CClaremout Business Park 2 Filing No. 1). 3

STREET IMPROVEMENT PLANS

APRIL 2020

EL PASO COUNTY FILE NO. SF-20-0014

STORM 10
STA 1+00.00 TO STA 4+07.61
(PRIVATE)

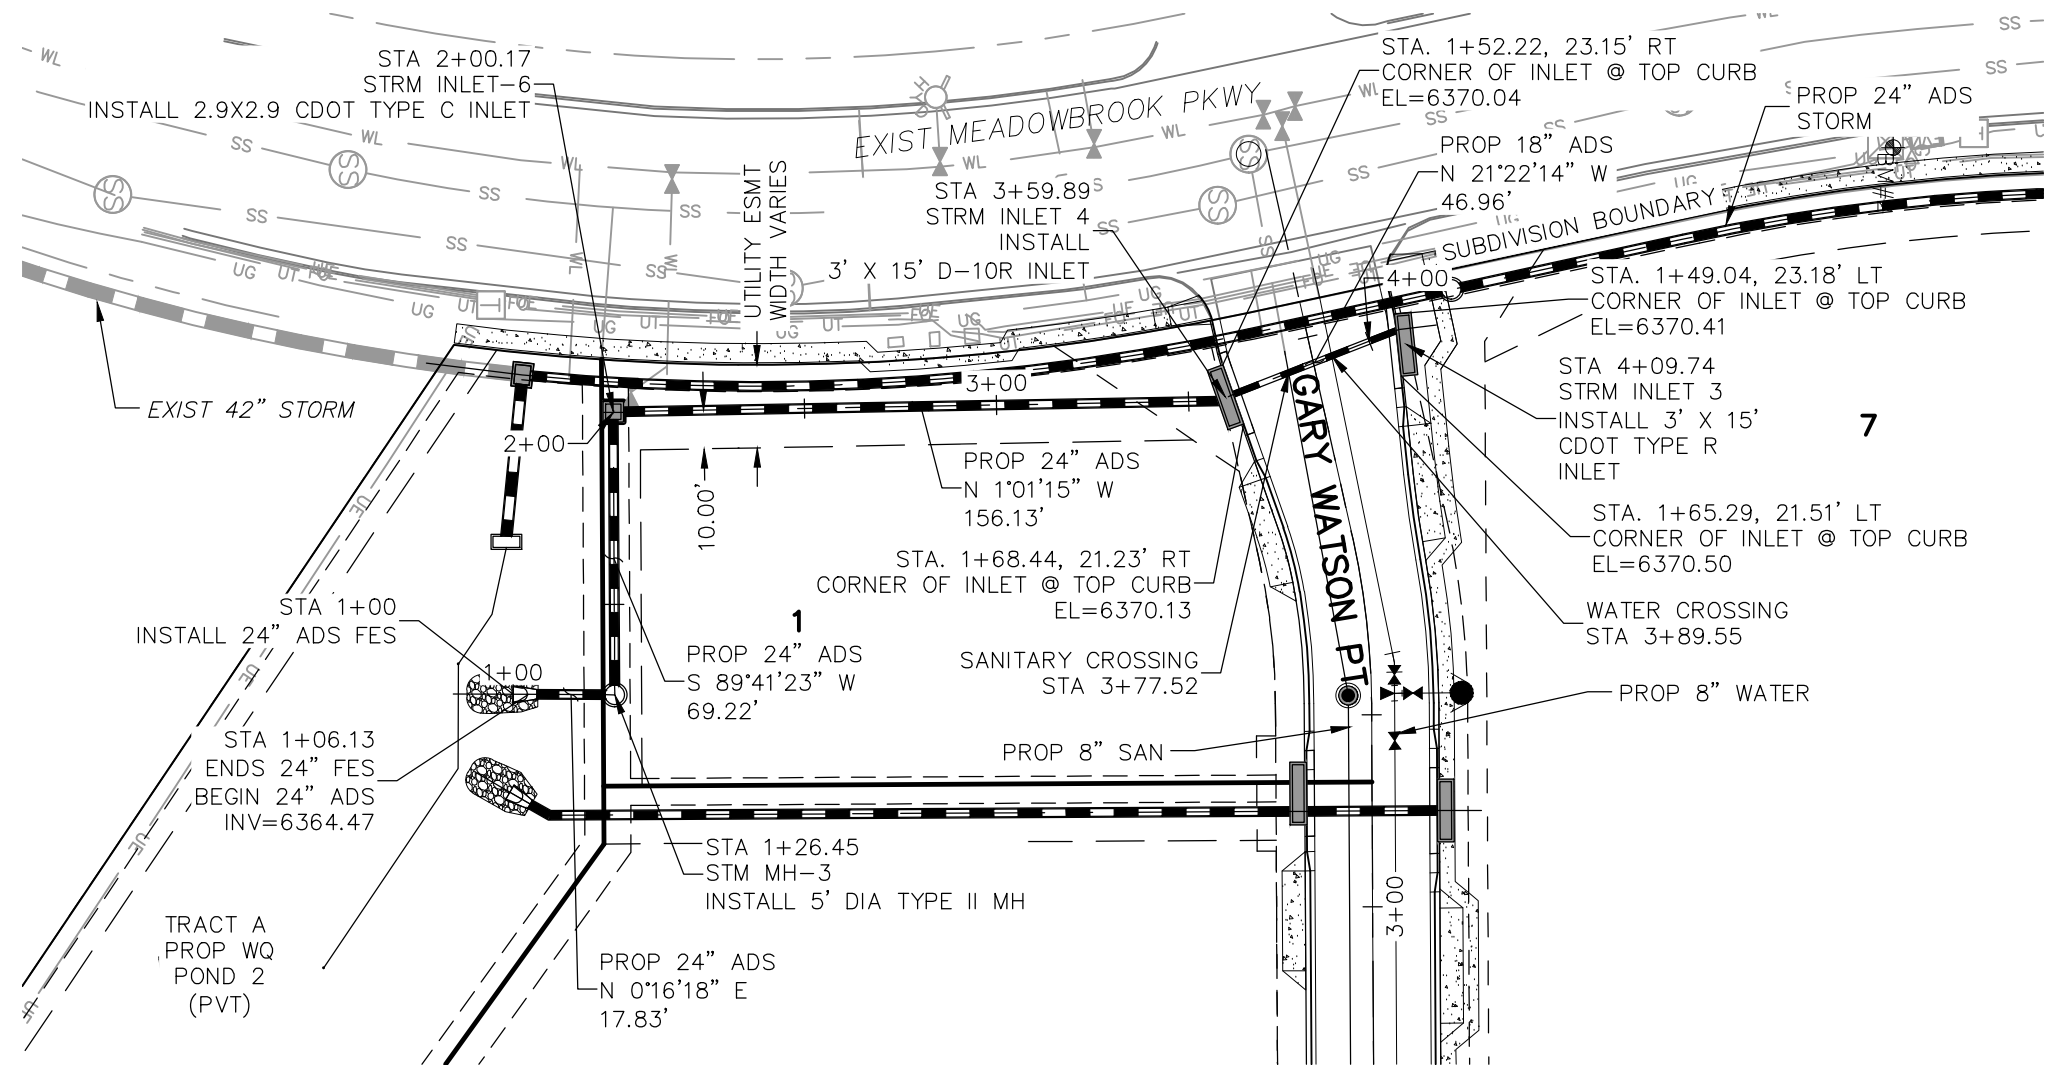
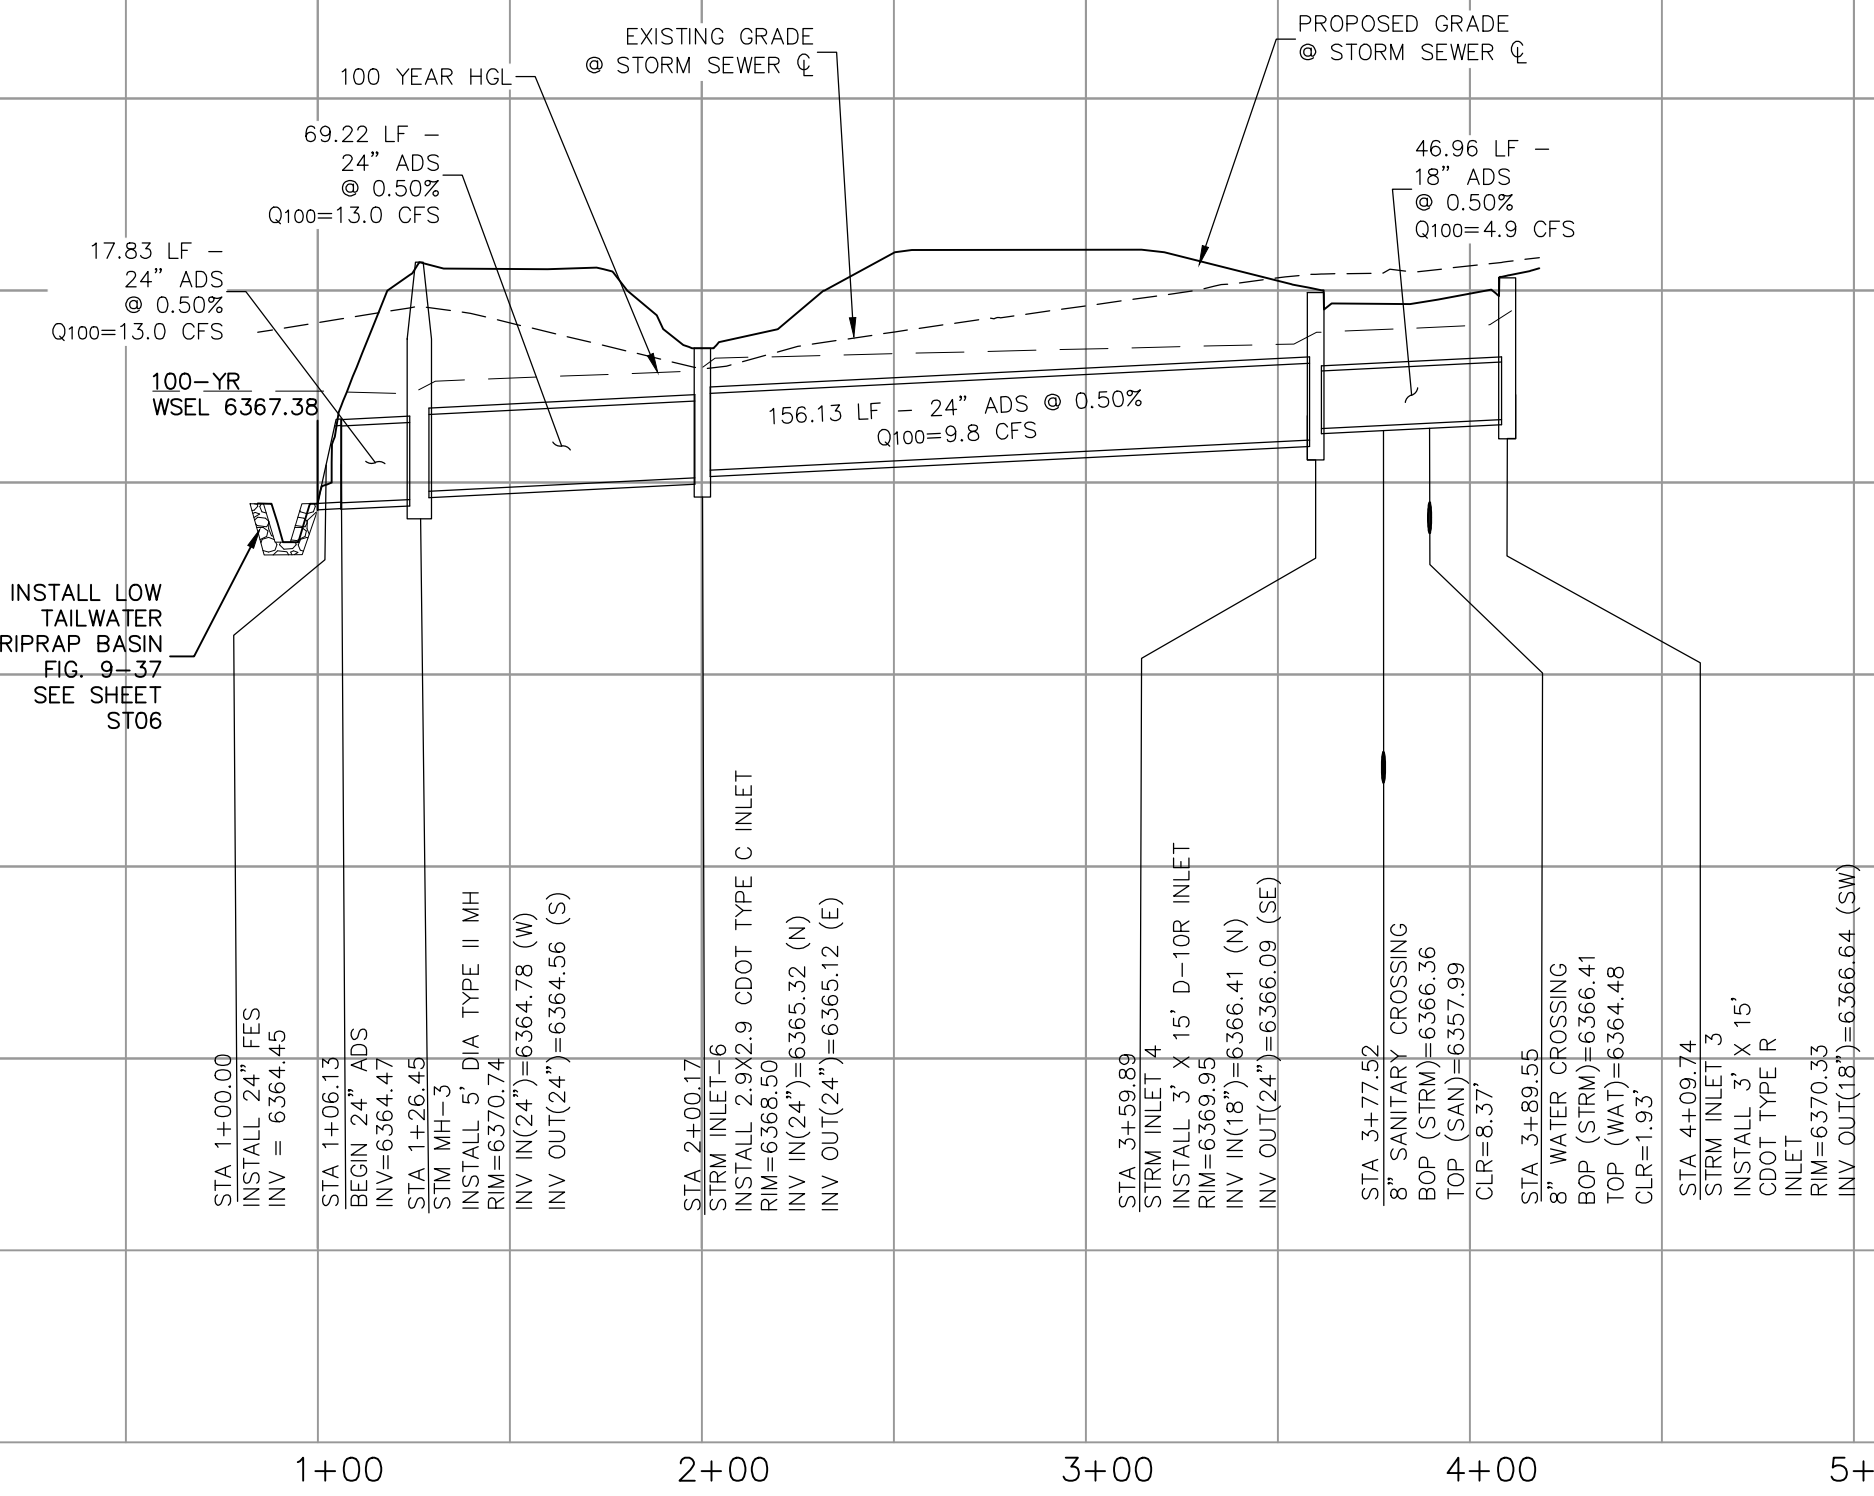
Please also identify the vertical scale
